**Re: Objection to MP08_0244 MOD 1 Modification Request for Mixed Used Development at 23-37
Lindfield Avenue and 11 Havilah Lane, Lindfield**

As a resident of Lindfield, I/we wish to lodge an objection against the proposed Modification of the subject development based on the following grounds:

1 SHADOW DIAGRAM - 21stDEC_9AM
5003 SCALE1 : 650

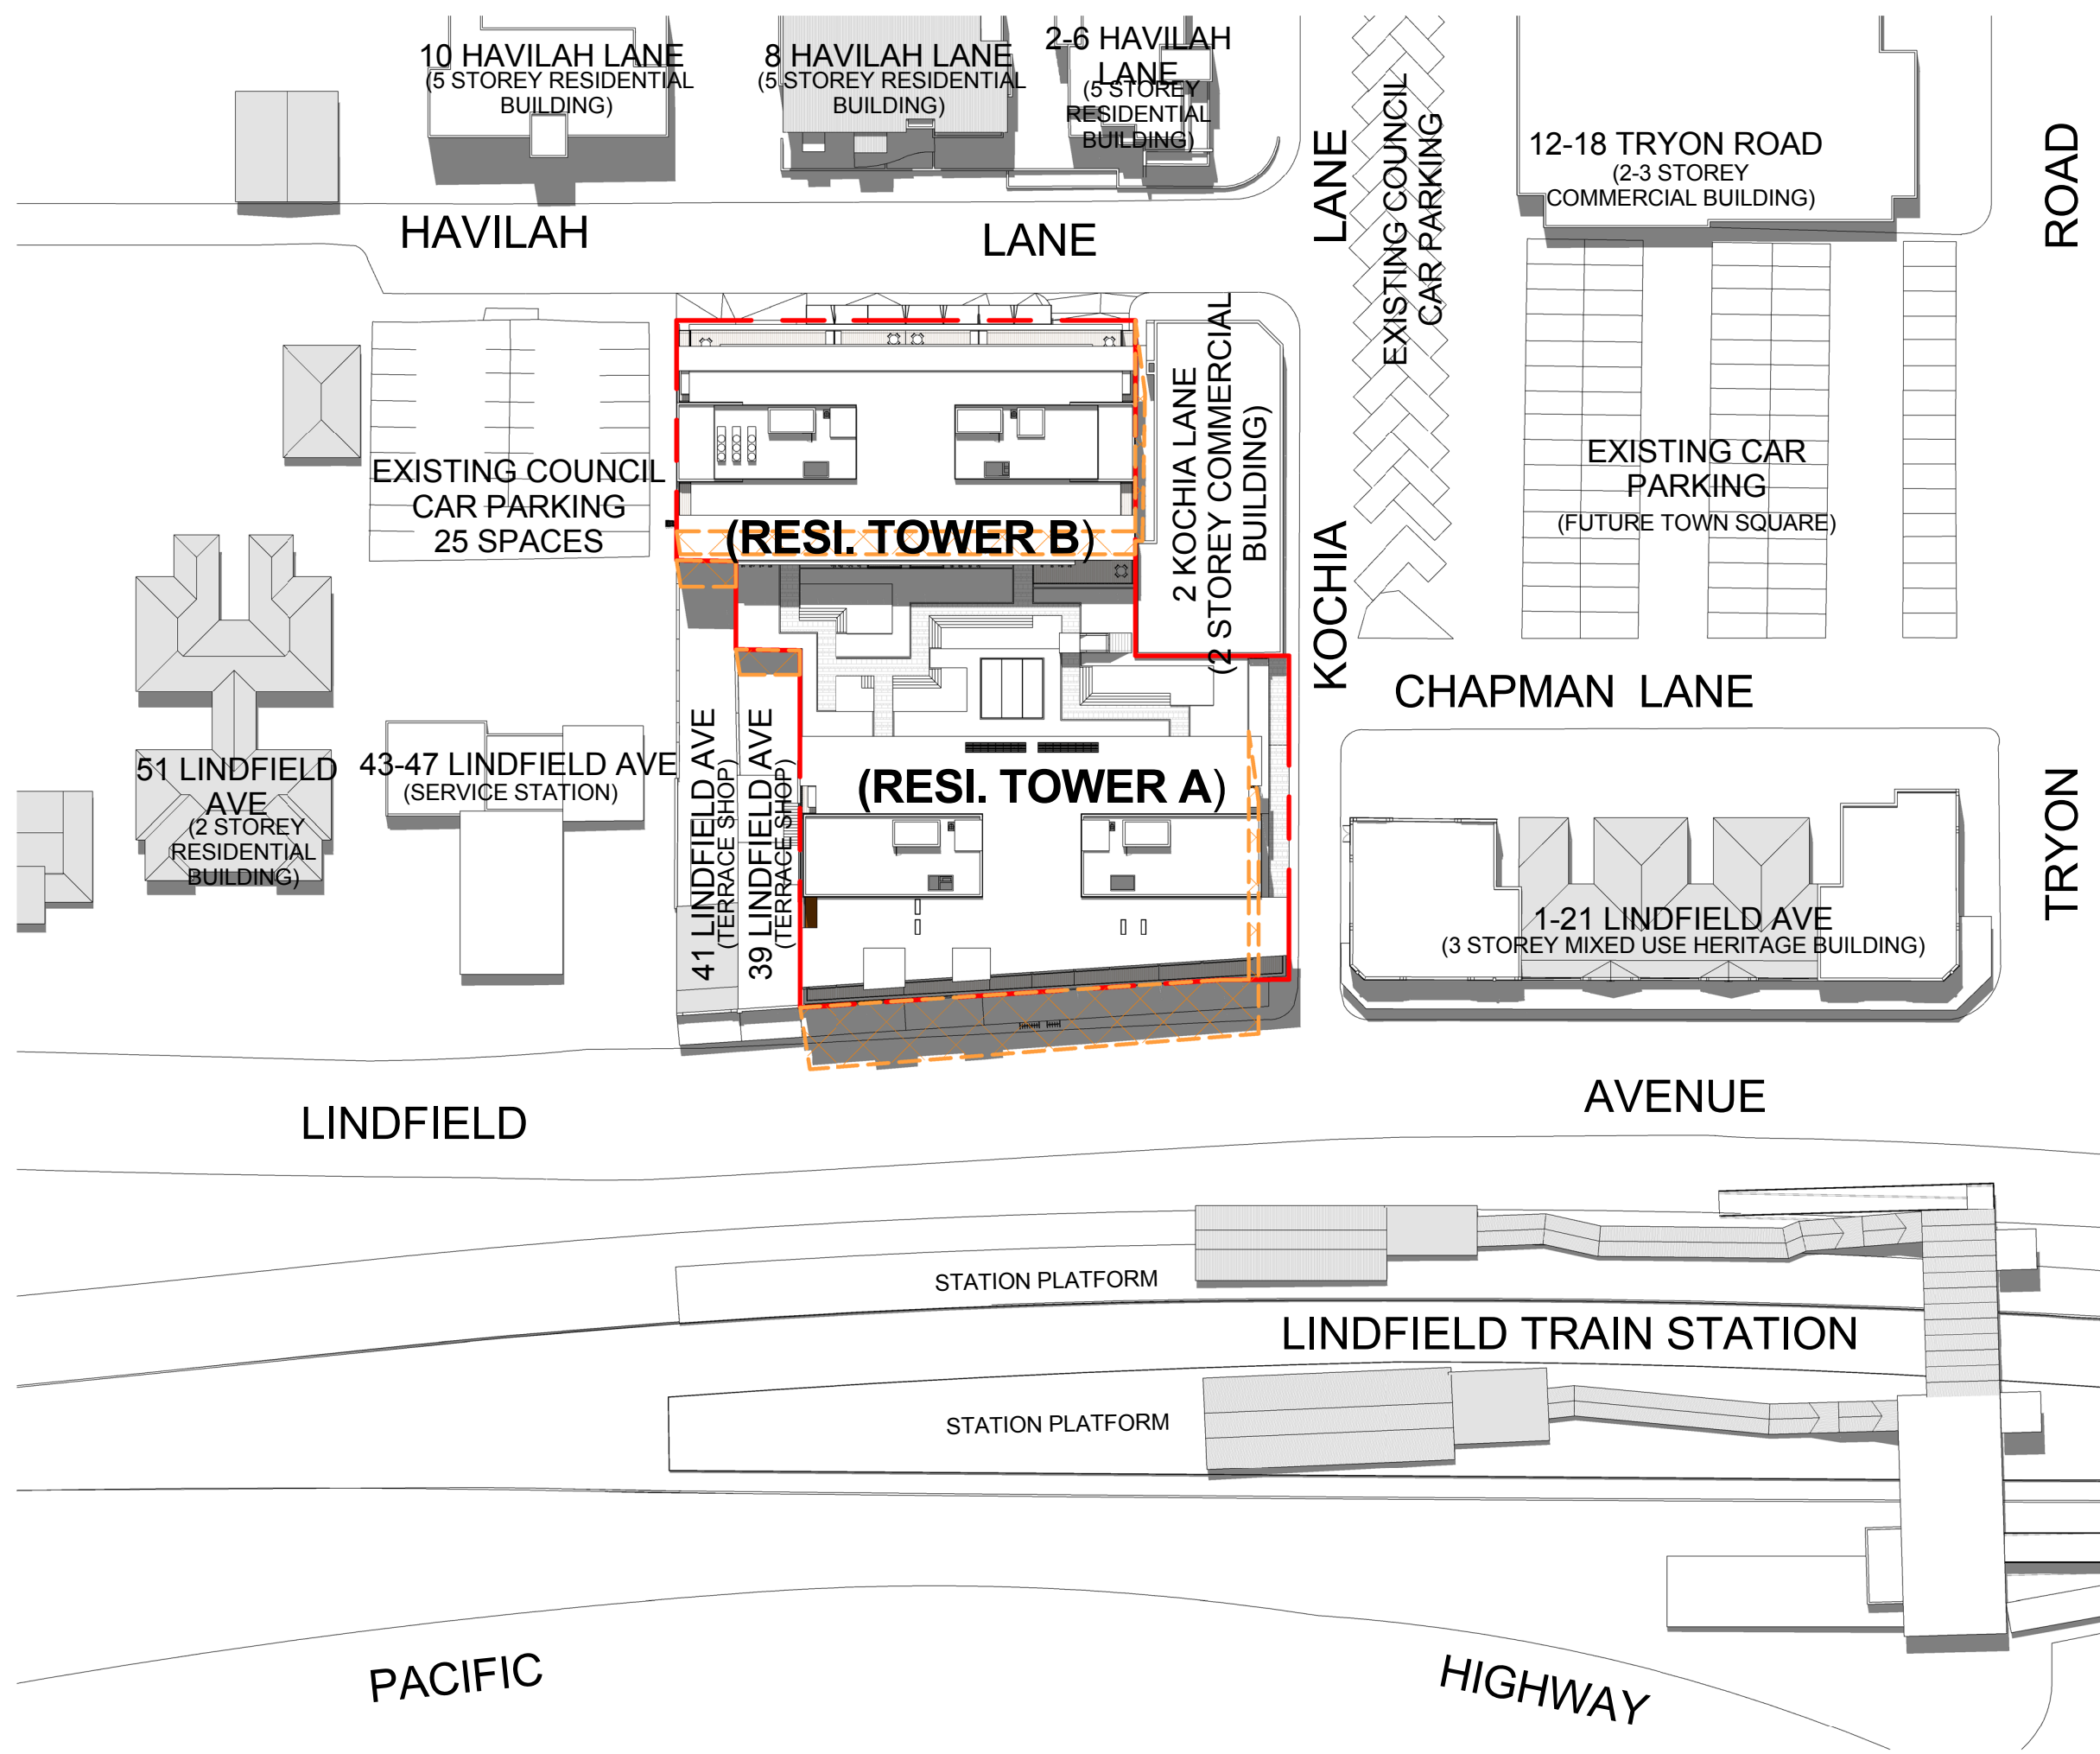
- The additional storeys create new adverse shadowing: a) for residents in the Havilah Lane apartments, particularly after 3pm b) for the popular outdoor café and central Lindfield hub area at 12 Tryon Road in afternoons, particularly in winter and c) for all commuters on the city bound Lindfield rail platform, instead of 50% of the year as approved, it will now be in shadow in the mornings 75% of the year
